East Park Energy: response to the Applicant's Technical Note on Replacement Works – assessment of key issues

Submission: Response to Applicant's Technical Note on Replacement Works/Responses to ExQ2

VIEWPORT 1: Great Staughton Road - 16.5m Articulated HGVs
Two-Way Movements (eastern section)

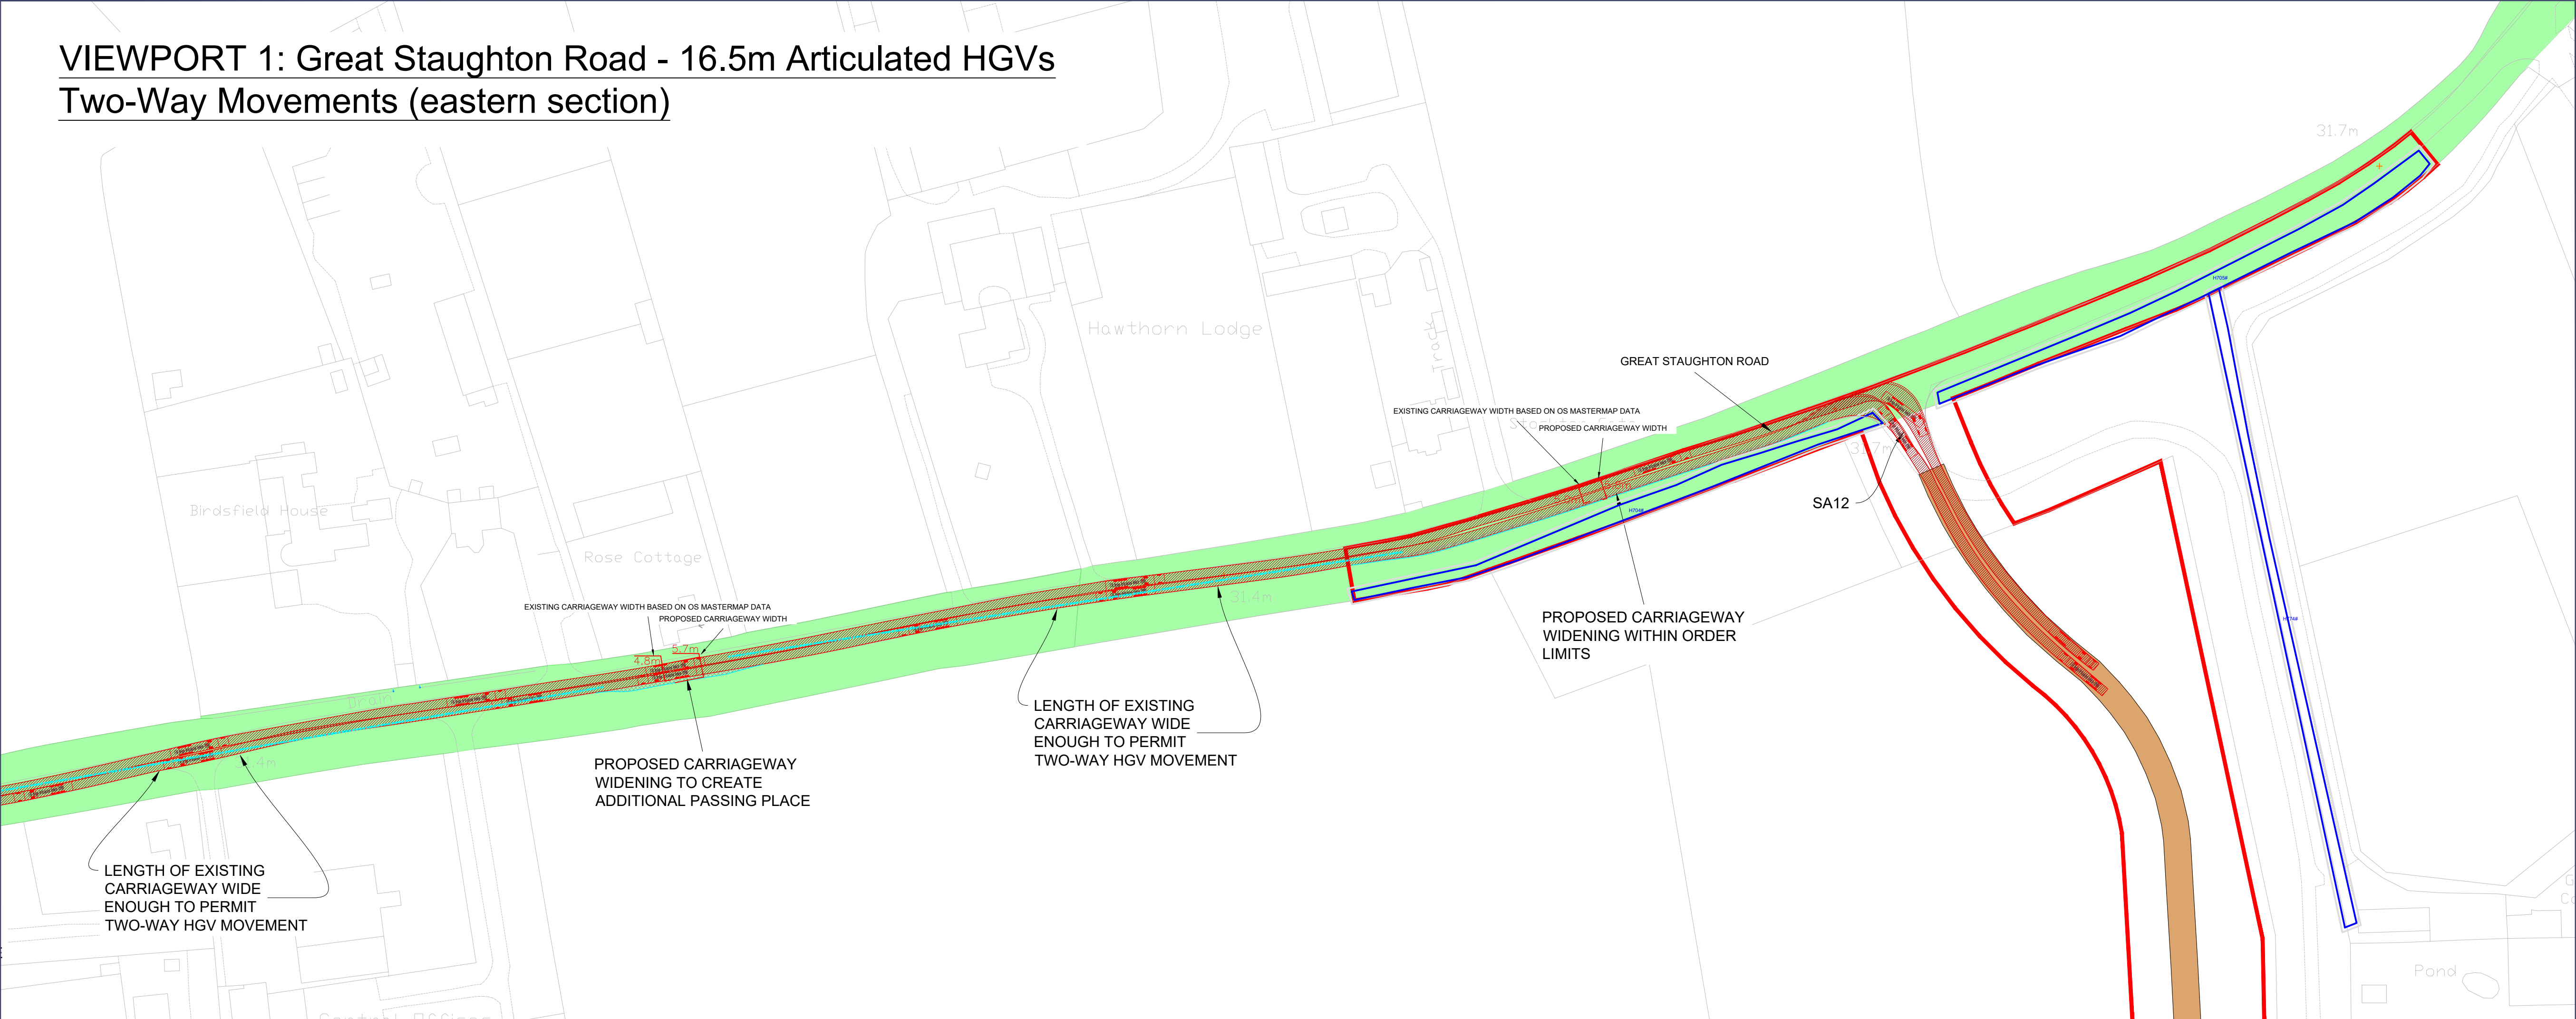
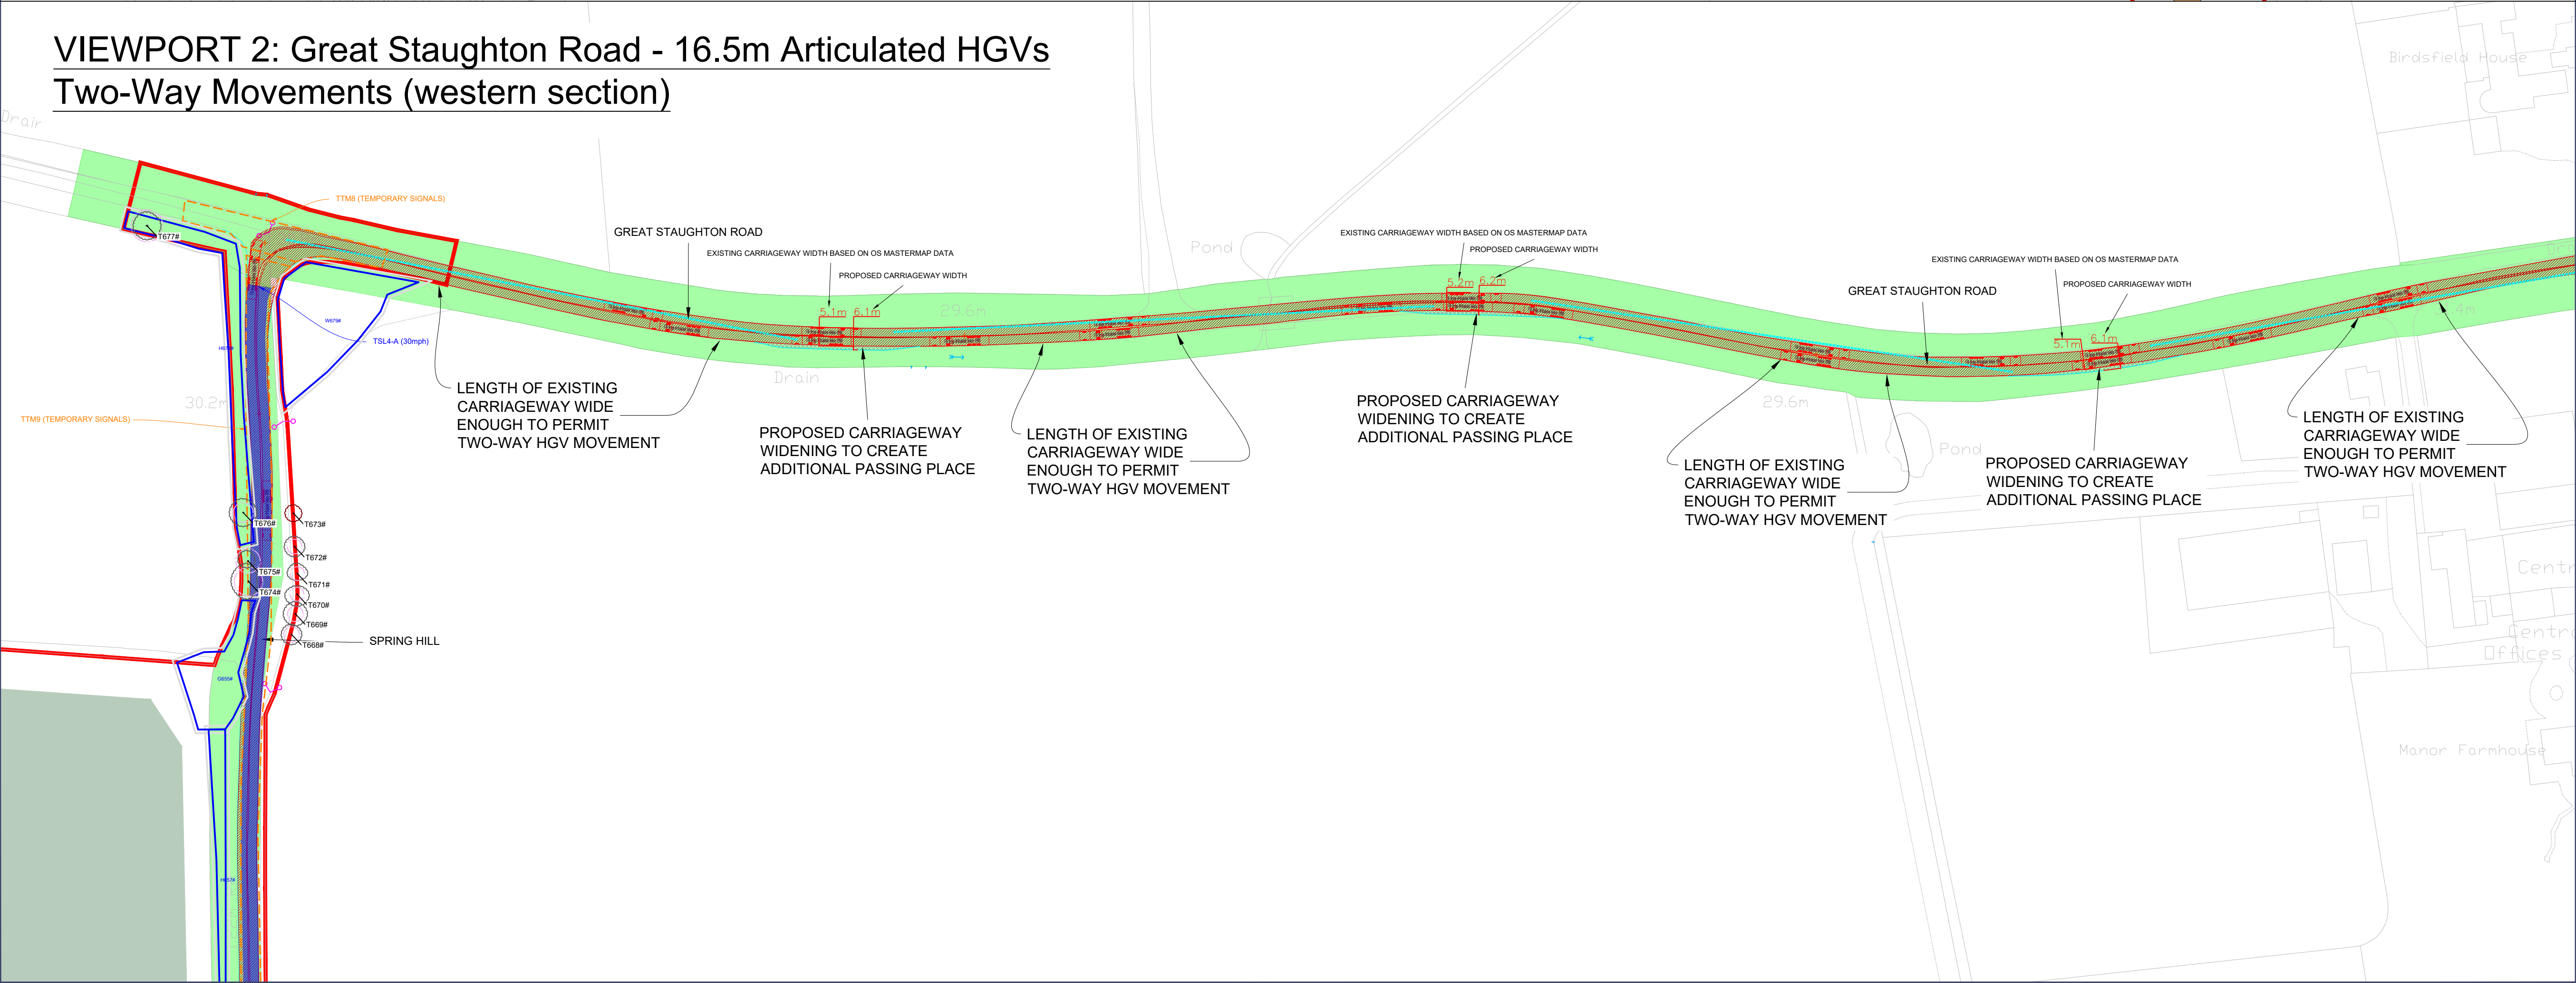
SEPE is concerned that the construction traffic will be routed through villages including Great Staughton and Pertenhall and would pass sensitive locations such as Great Staughton Primary School. This is confirmed by the Applicant in Figure 1 – Proposed Operational Phase Access Strategy, which defines the operational access route utilising sections of existing public highways and at paragraph 3.6.12:

“....vehicle movements during the operational phase, including replacement activities, would be required to route along sections of the public highway network which were not used during the construction phase, specifically Moor Road; B645 The Highway through Staughton highway; Causeway / The Town through Great Staughton; and Little Staughton Road and B660 Kimbolton Road through Pertenhall.”

At paragraph 3.6.22, the Applicant downplays the impact on the village and school:

“Furthermore, as noted, the duration of the impacts in this scenario would be commensurately reduced, with effects through Great Staughton limited to a 10-week period”

SEPE assumes this 10-week period occurs each year of the replacement works, so would equate in total to approximately one year of adverse effects on the villages, Great Staughton Primary School and other communities.

SEPE submits that this is an important issue, especially because of the potential adverse effects on sensitive locations such as Great Staughton Primary School. There is no evidence presented by the Applicant that the need to route HGV and LGV vehicles and other additional construction traffic trips through villages during the replacement works stage has been discussed and agreed with the local authorities.

SEPE also submits that the plan set out in Table 5.5 represents a materially different routing strategy from that adopted during construction and further illustrates why replacement activities cannot simply be assumed to give rise to lower environmental effects than construction without assessment of the different routes and receptors affected.
